Final Comments - Appellant App/R5510/W/22/3301645

August 2022

- 0.1 An Appeal has been filed for determination by the Planning Inspectorate of Application Ref 23469/APP/2022/144 submitted to the LB of Hillingdon. The application was for *“Erection of new 3 bedroom bungalow with dormers and rooflights serving accommodation in the roof on land to the front of existing dwelling.”*

PROPOSED GROUND
FLOOR PLAN

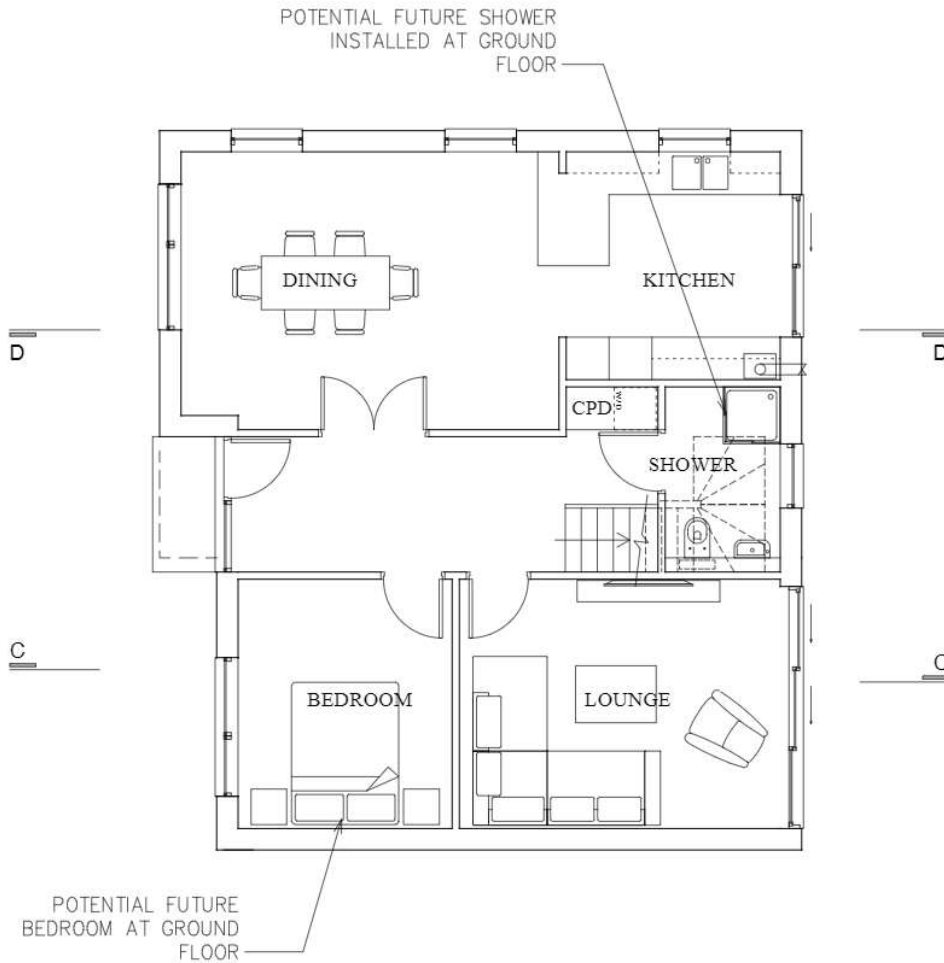
- 0.6 A third reason for refusal has been given as: *“The proposal fails to provide a step free access for the new dwelling and fails to meet the internal floorspace and layout standards set out in Diagram 28 of Approved Document M to the Building Regulations...”*

- 4.6 The internal layout of the ground level W/C has been amended to demonstrate compliance with Part M4(2) standard. Manoeuvring circles have been added to the primary habitable rooms and clear dimensions and offsets to the door handle approaches are illustrated on the attached plan. Lifetime Homes standards (no longer a requirement) which called for adaptability to provide a bed space at ground floor level has also been incorporated although the intention would remain to provide a 3 bed dwelling as part of this application. Space standards in bedrooms including the principle bedroom at 1st floor level have also been shown. The ensuite bathroom to this principle bedroom also illustrates compliance with Category 2 standard as required.
